From: Laura Gibbons
Sent: 04 February 2019 15:27
To: Planning.Responses
Cc: Anita Gardner; Michael Eastham
Subject: RE: Planning Consultation on: LU/379/18/RES

Engineers Comments Regarding Surface Water Drainage

Site Address: Parcel A2/B6 Hampton Park Toddington Lane Littlehampton
BN17 7PL

Description of Works: Approval of reserved matters following outline consent
LU/47/11/ for 50 No. dwellings. This application may affect the
setting of a listed building.

A	23/11/18	Revised to incorporate layout changes and Highway comments.	AJW
REV. No.	DATE	DESCRIPTION	INITIALS
Client	Persimmon Homes (Thames Valley)		
Project	Phase 3 Littlehampton		
Title	Drainage Plan		
Scale	1:250 @ A0	Date	June 2018
Checked	KTG	Drawn	AJW
Drawing No.	5825:01		
Rev	A

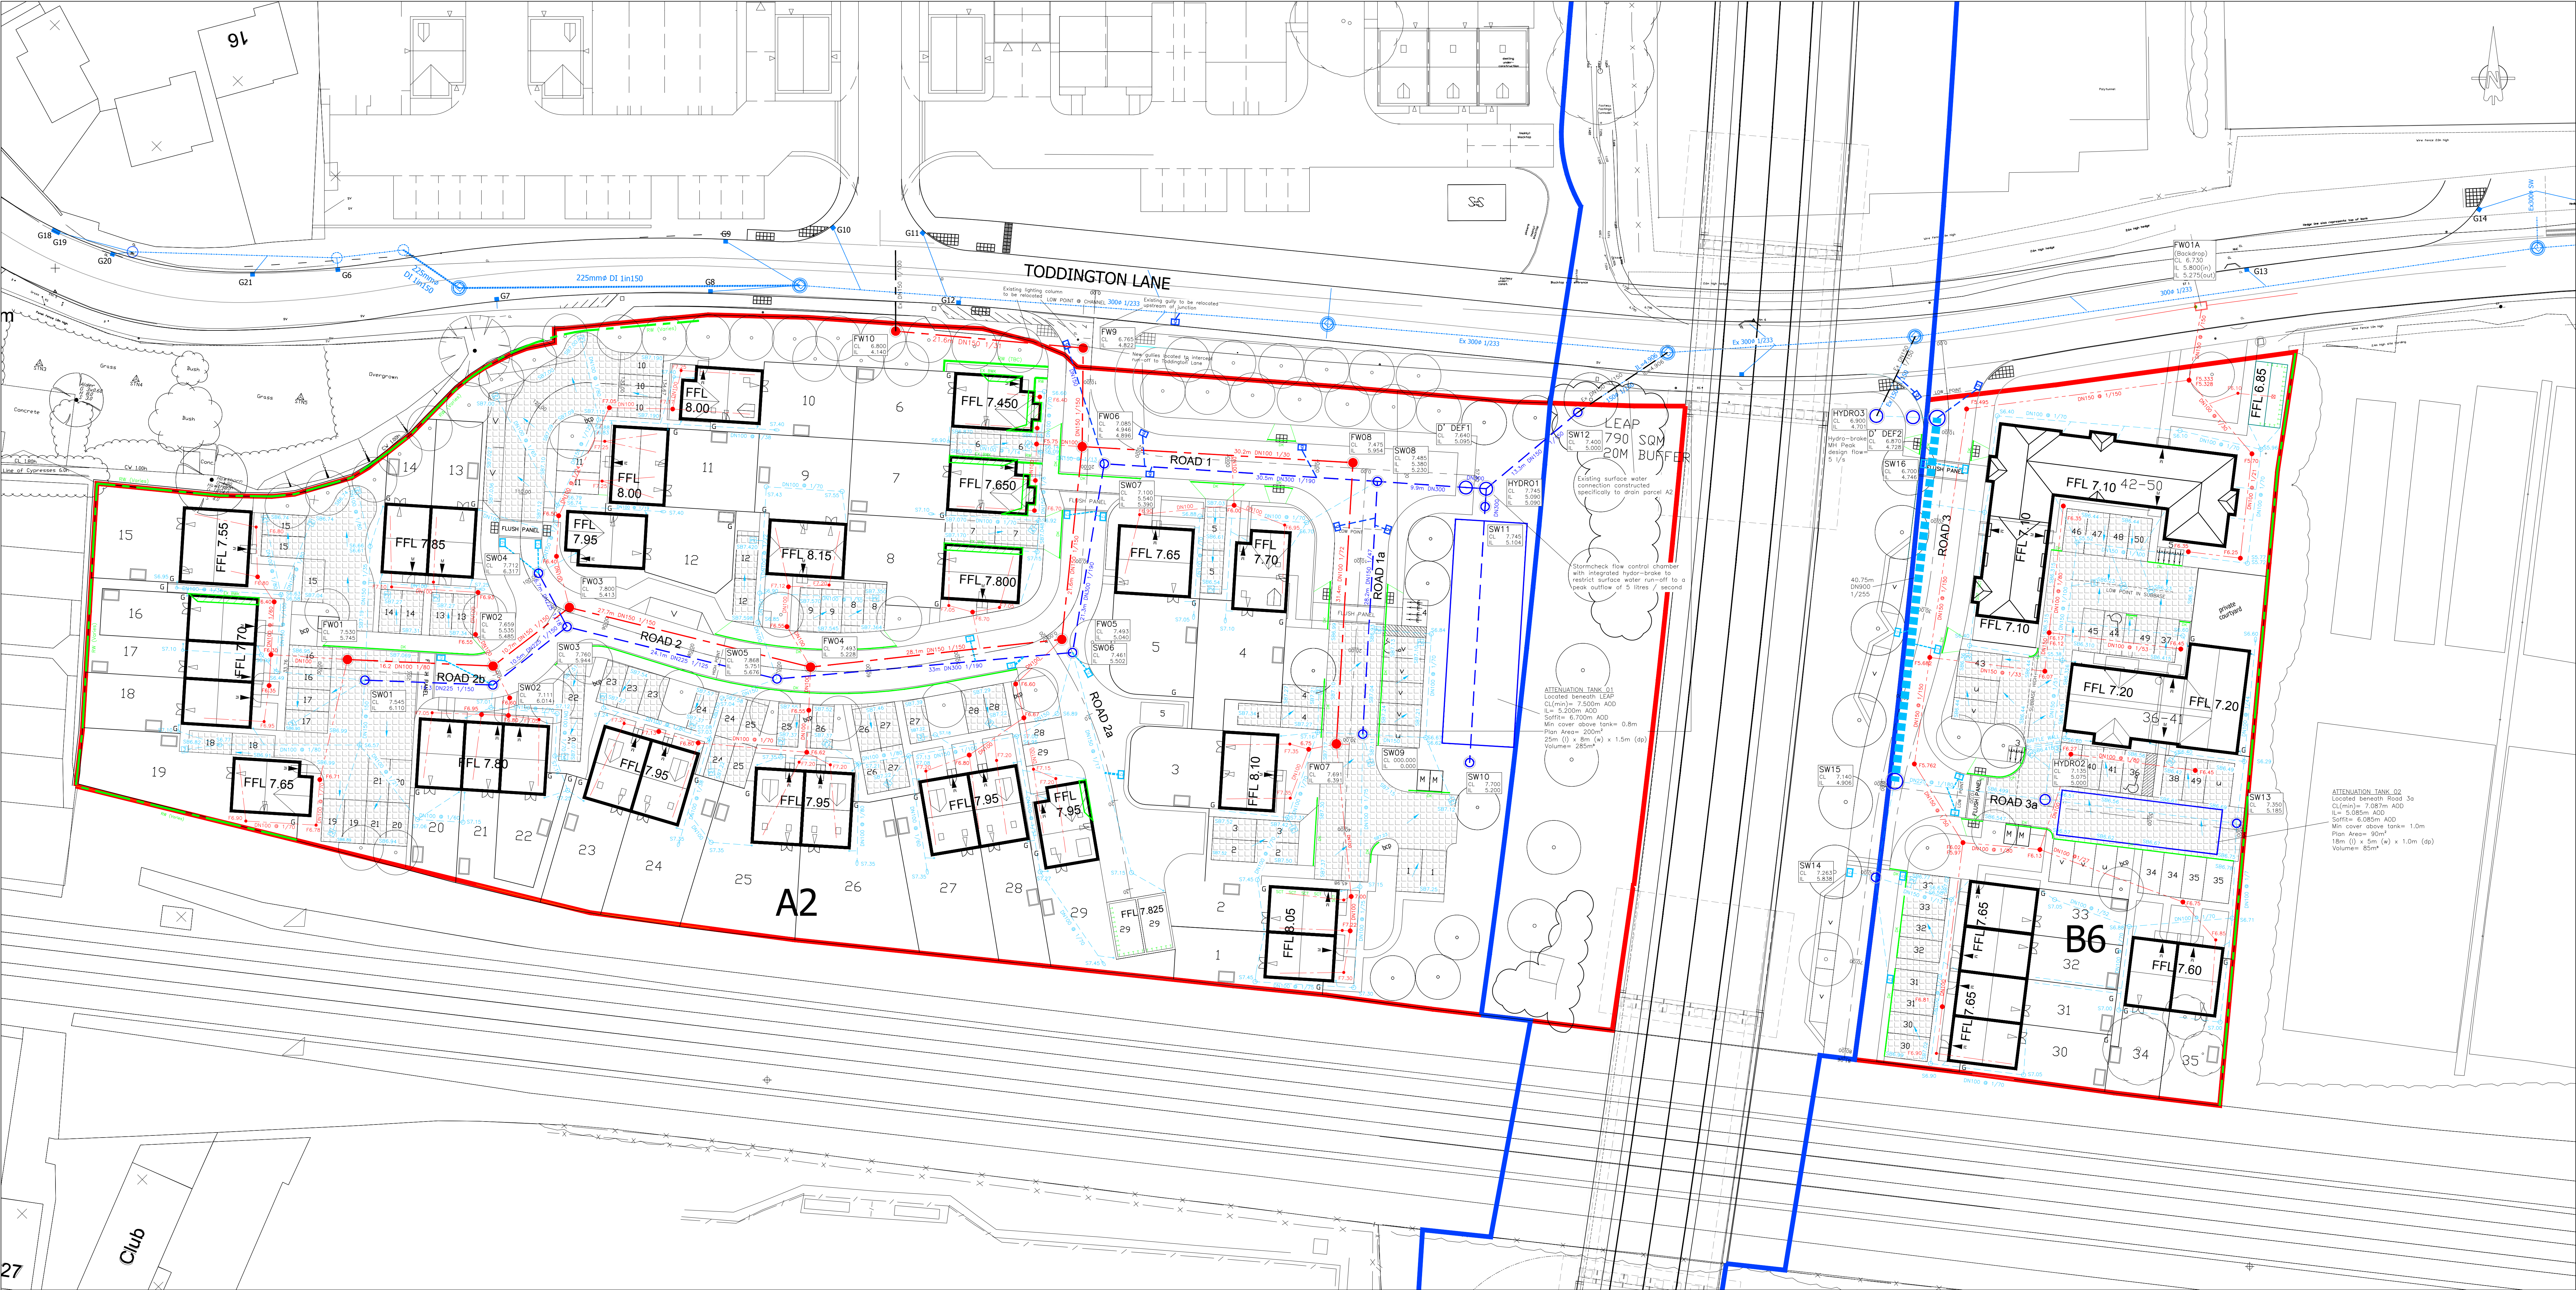
The wider drainage strategy for the development has allowed for 5l/s from parcel A2 and 5l/s from parcel B6. The surface water drainage plan submitted states that discharge will be limited to these rates. However, the proposal for parcel A2 is unacceptable, we do not permit attenuation tanks to be located beneath play equipment. Furthermore, no calculations have been submitted to demonstrate that there is adequate space within either parcel for surface water drainage features. I believe there is also currently conflict between the proposed planting scheme and drainage scheme. Surface water drainage features should not be designed to be within potential root protection areas.

Until further information is submitted I object to the proposals as submitted as it has not been demonstrated that the sites can be drained with the constraints proposed, i.e. landscaping and play areas. I have attached our checklist which explains the level of detail we require for discharge of conditions applications, however, I recommend drainage is given full consideration at this stage as a result of the confined nature of the parcels.
